Pre-Application Advice

Proposed residential development of former warehouse site.

Land at number 57 River Road Littlehampton BN175DD

DRAWING NO: 1908_P_202 REVISION 02
TITLE: PROPOSED SECOND FLOOR PLAN

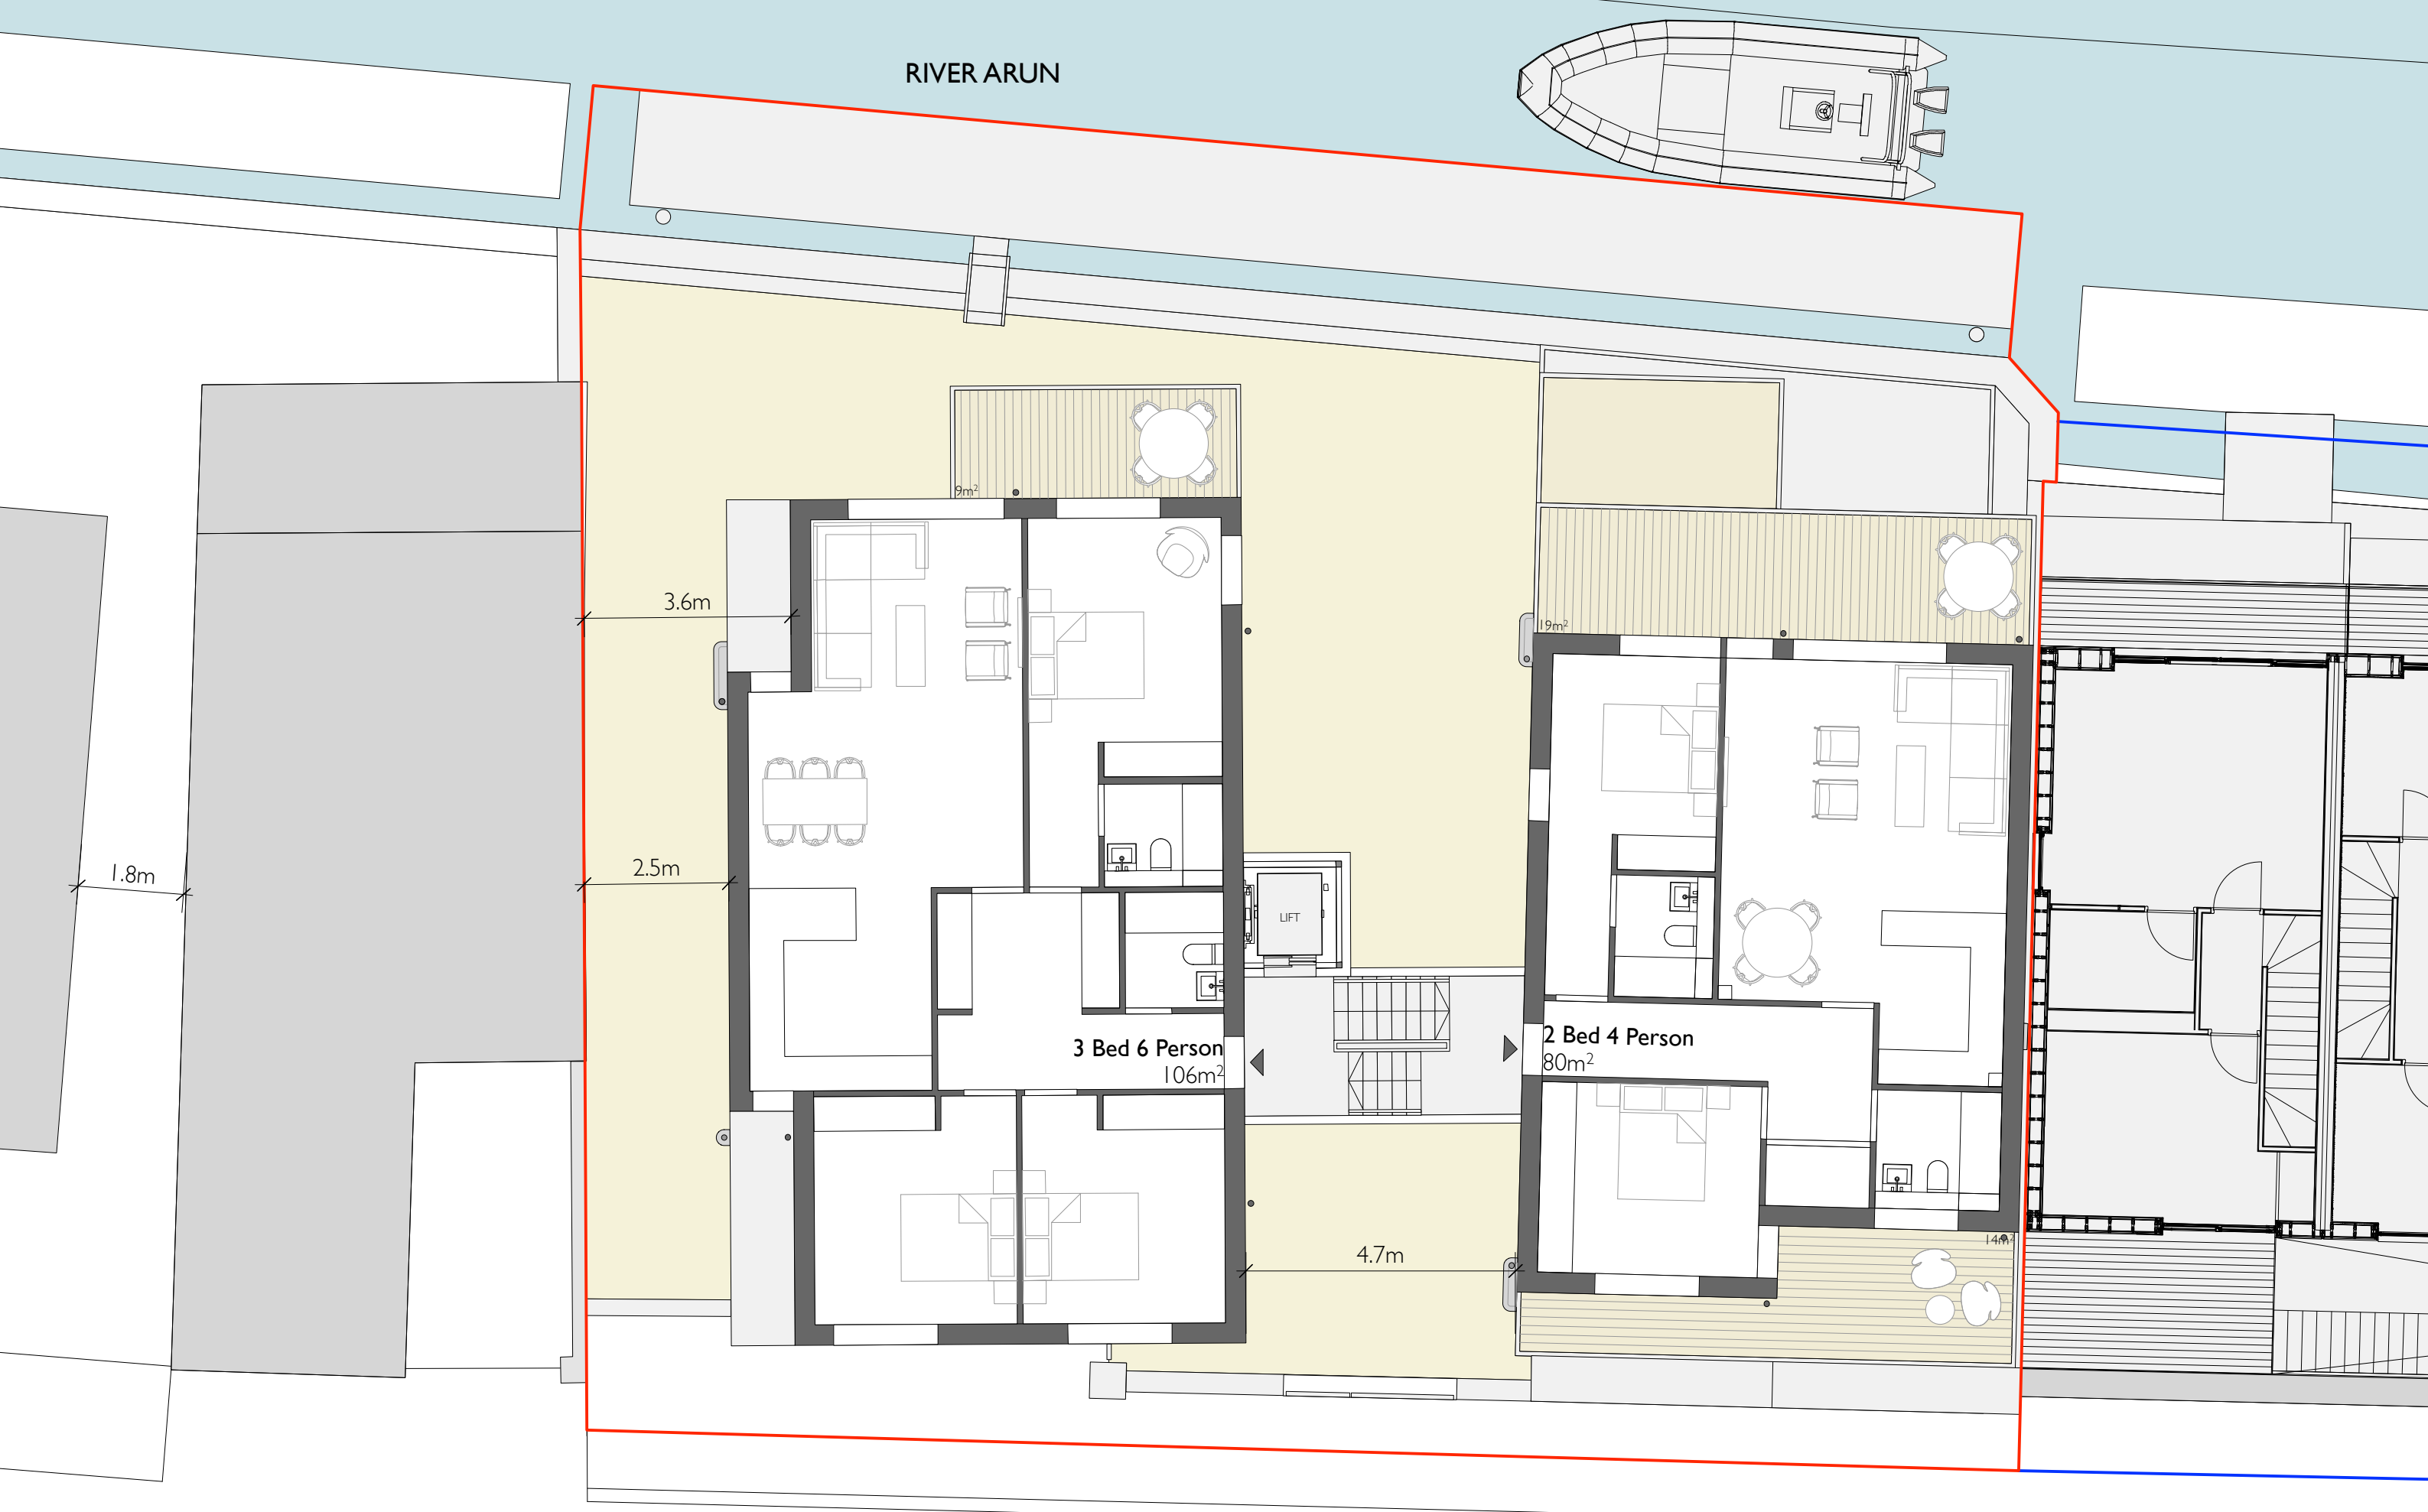
One suggestion to amend the design would be to increase the gap between the southern building and the neighbouring non-designated heritage asset. Additional floor space could be provided by pushing the building back further into the plot and utilising the space behind the lift shaft.

DRAWING NO:	1908_P_401
TITLE:	STREET SCALE
PROJECT:	57 RIVER ROAD, LITTLEHAMPTON

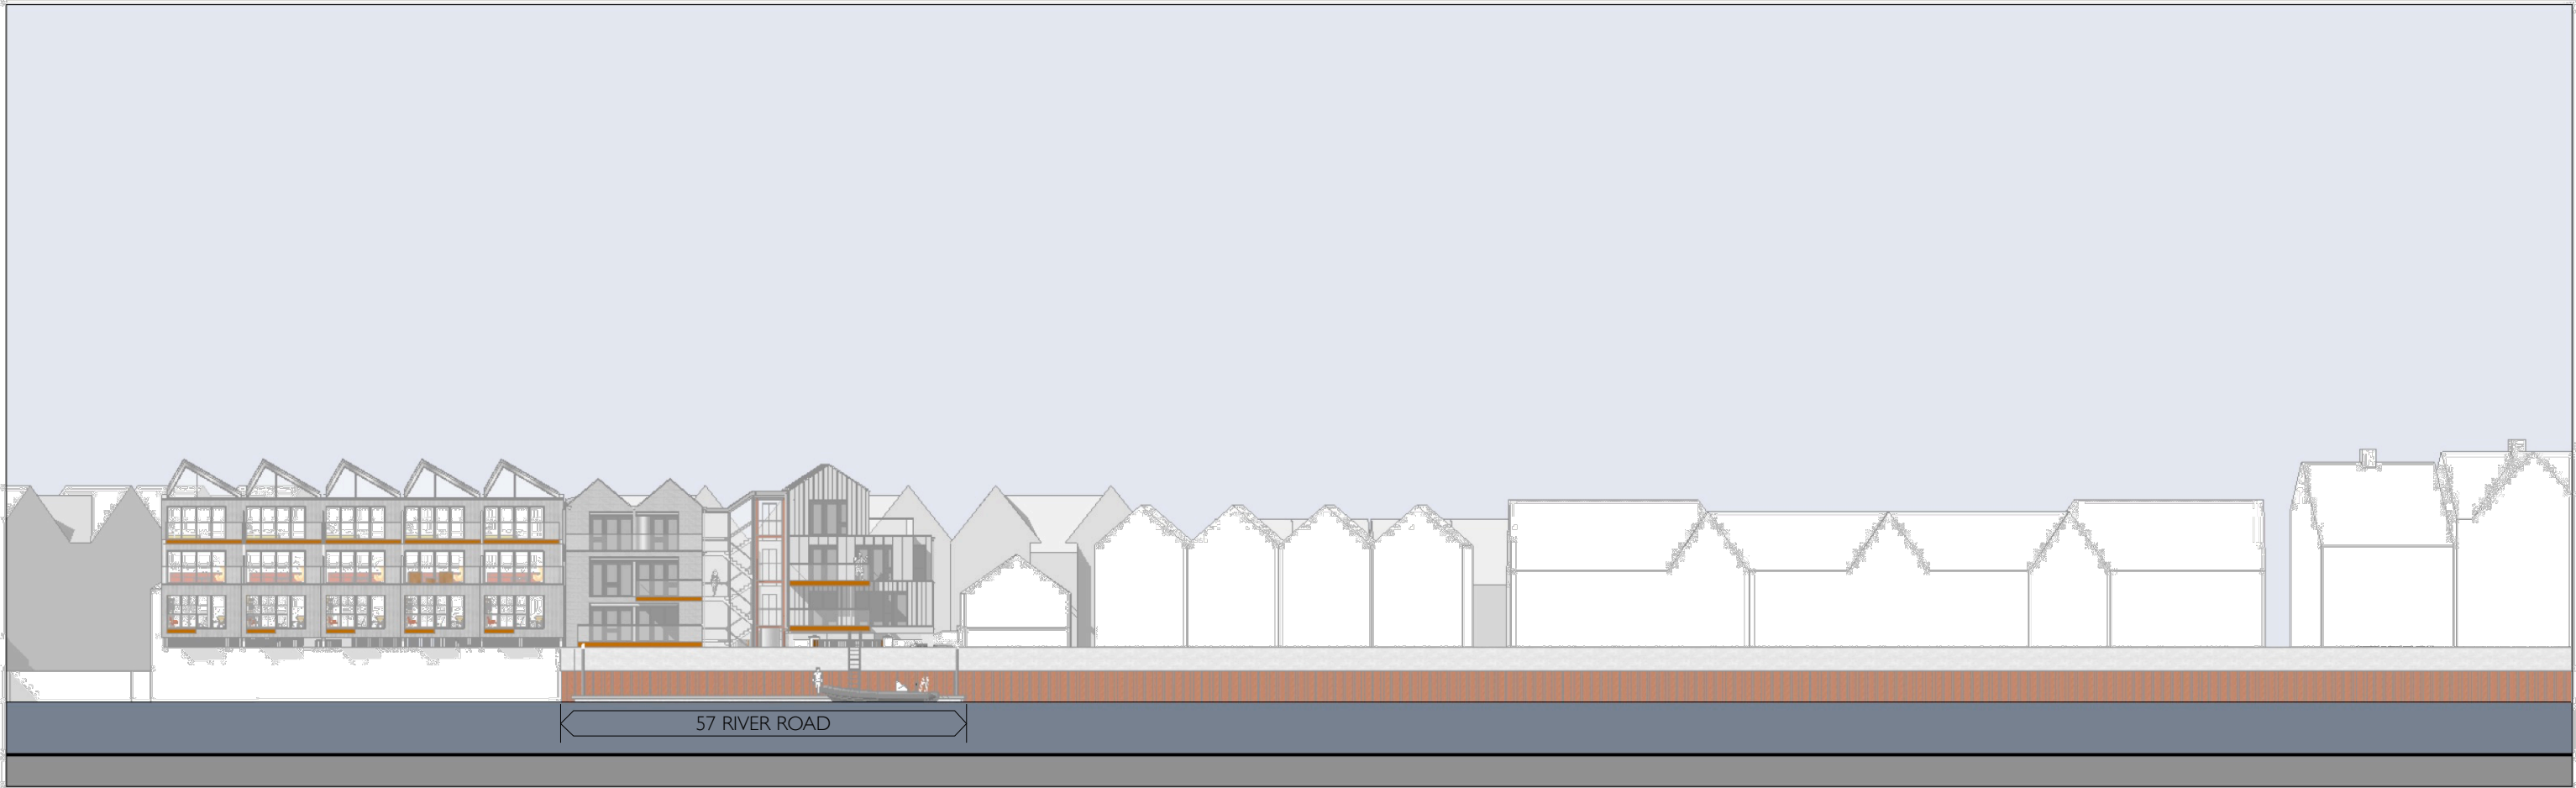
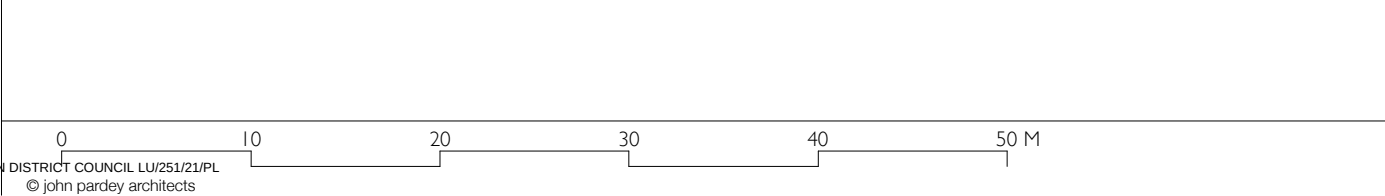
16) It would be helpful to have a wider street scene elevation or a section to allow an informed assessment of the wider environs of the CA
